Application no: **3/2023/0274**

Address: **Laneside Barn, Grindleton Road, Grindleton, Clitheroe, BB7 4QH**

Proposal: **Proposed demolition of the existing agricultural building and erection of one new detached dwelling.**

The Local Highway Authority have viewed the plans and highway related documents and have the following comments to make:

Drawn: MCK	Checked:	Scale: 1:200	Date: 01-02-23
Job No: 22-150	Drawing No: SP-01	Rev: A

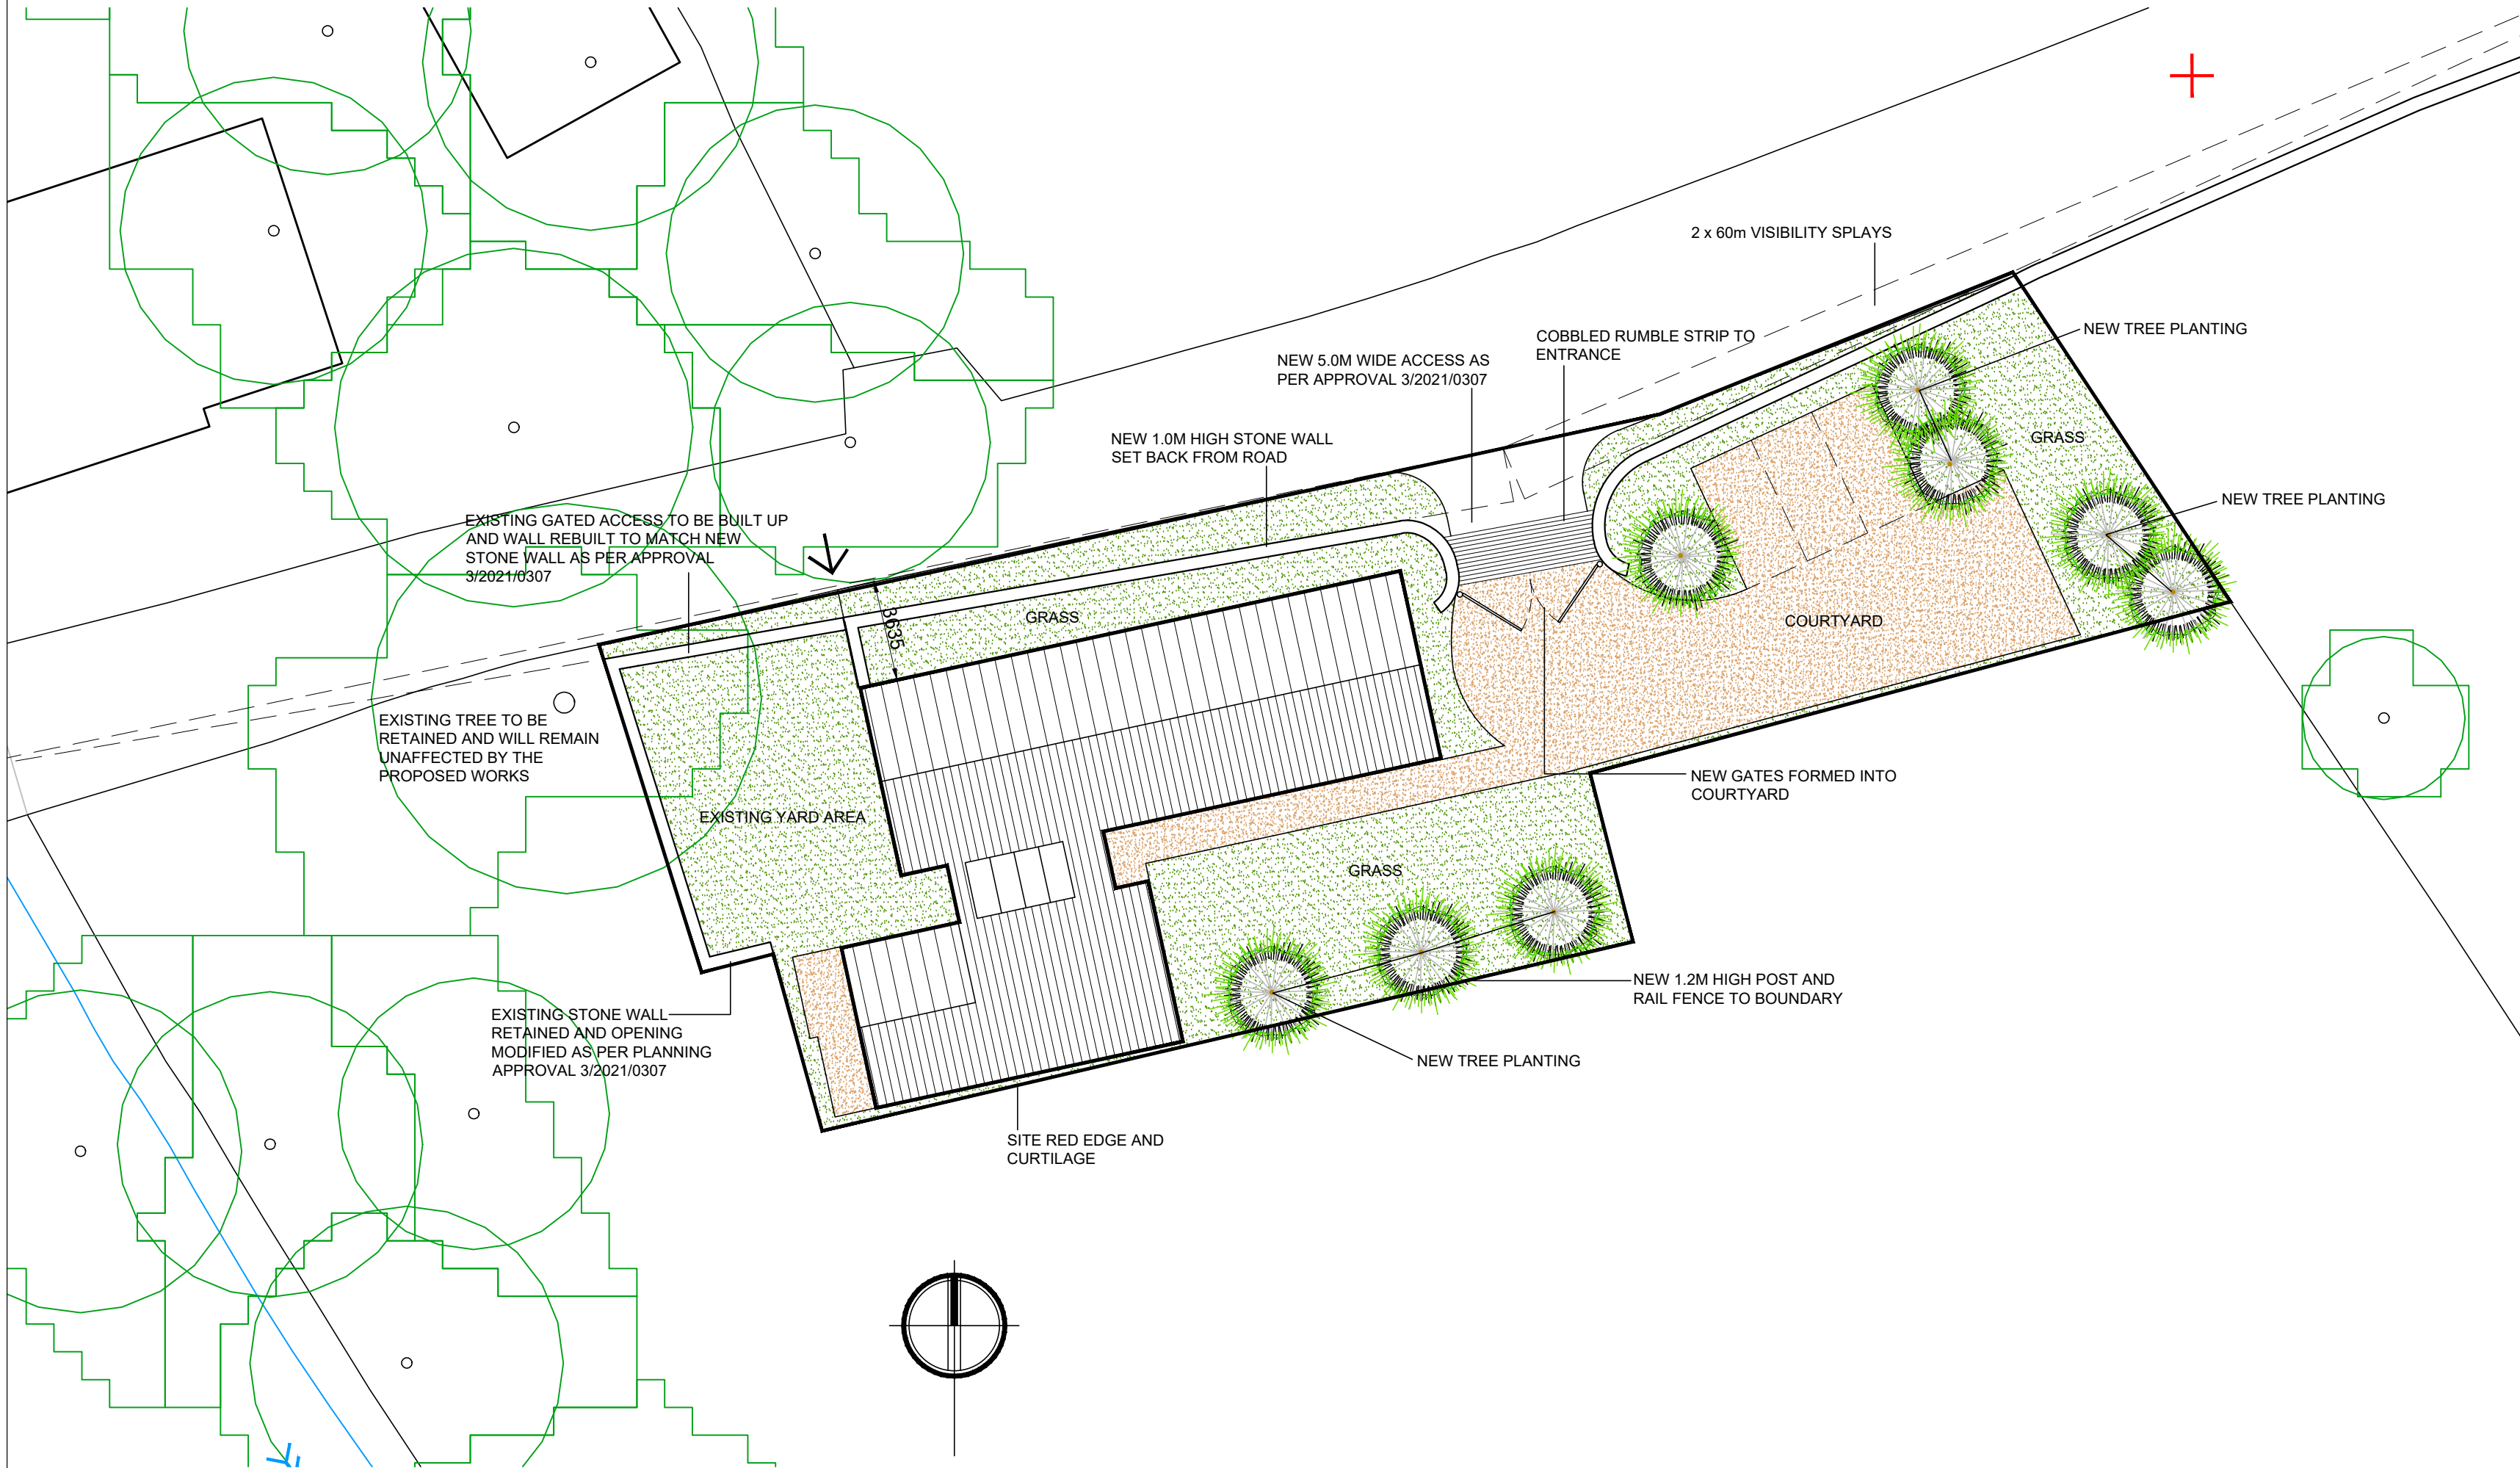
The LHA have reviewed MCK drawing number SP-01 Rev A titled "Proposed Site Plan" and are aware that the proposed access will be 5m wide. This complies with the LHAs guidance when serving a single dwelling.

The LHA have further reviewed MCK drawing number SP-01 Rev A and are aware that the proposed access can provide visibility splays of 2m x 60m in both directions. These visibility splays do not comply with the LHAs guidance, with the LHA requiring visibility splays of 2m x 214m in both directions given the speed of Grindleton Road.

Despite this, the LHA will accept the shortfall in visibility. This is because the visibility splays were seen as acceptable by the LHA during application references 3/2021/0307, 3/2019/0760 and 3/2019/0389 with the proposals taking potentially slow moving, large agricultural traffic off the highway network. Therefore, the LHA will accept the provided visibility splays.

The LHA remind the Agent that the alteration to the access is subject to a Section 278 agreement. The LHA will also request as part of the Section 278 works, a kerb line to be erected where the proposed grass verge is provided at the back of the carriageway. This is to ensure that surface water from the highway does not enter the site due to the gradient of the adopted highway. A gully is also likely to be needed so that the water from the adopted highway can drain naturally. These works will all be at the cost of the Applicant and the works will need to occur immediately once the building is demolished due to the building acting as a retaining structure.

The LHA have reviewed MCK drawing number SP-01 Rev A and are aware that 3 car parking spaces will be provided for the proposed 4 bed dwelling which complies with the LHAs parking guidance as defined in the Joint Lancashire Structure Plan.

The LHA will condition that a minimum of one car parking space provides an electric vehicle charging point and that some form of cycle storage provision is provided at the site.

- Kerb line to be erected at the back of the carriageway, where the grass verge is proposed for the full length of the site.
- Stopping up of the access which serves the existing yard area.
- A gully to be provided along the proposed kerb line.
- Demolition of the existing agricultural building which fronts the adopted highway.

3. No part of the development hereby permitted shall be occupied until such time as the access arrangements shown on MCK drawing number SP-01 Rev A have been implemented in full.

5. No part of the development hereby permitted shall be occupied until such time as vehicular visibility splays of 2 metres by 60 metres have been provided at the site access. These shall thereafter be permanently maintained with nothing within those splays higher than 1 metres above the level of the adjacent footway/verge/highway.

6. The development hereby permitted shall not be occupied until such time as the parking and turning facilities have been implemented in accordance with MCK drawing number SP-01 Rev A. Thereafter the onsite parking provision shall be so maintained in perpetuity.
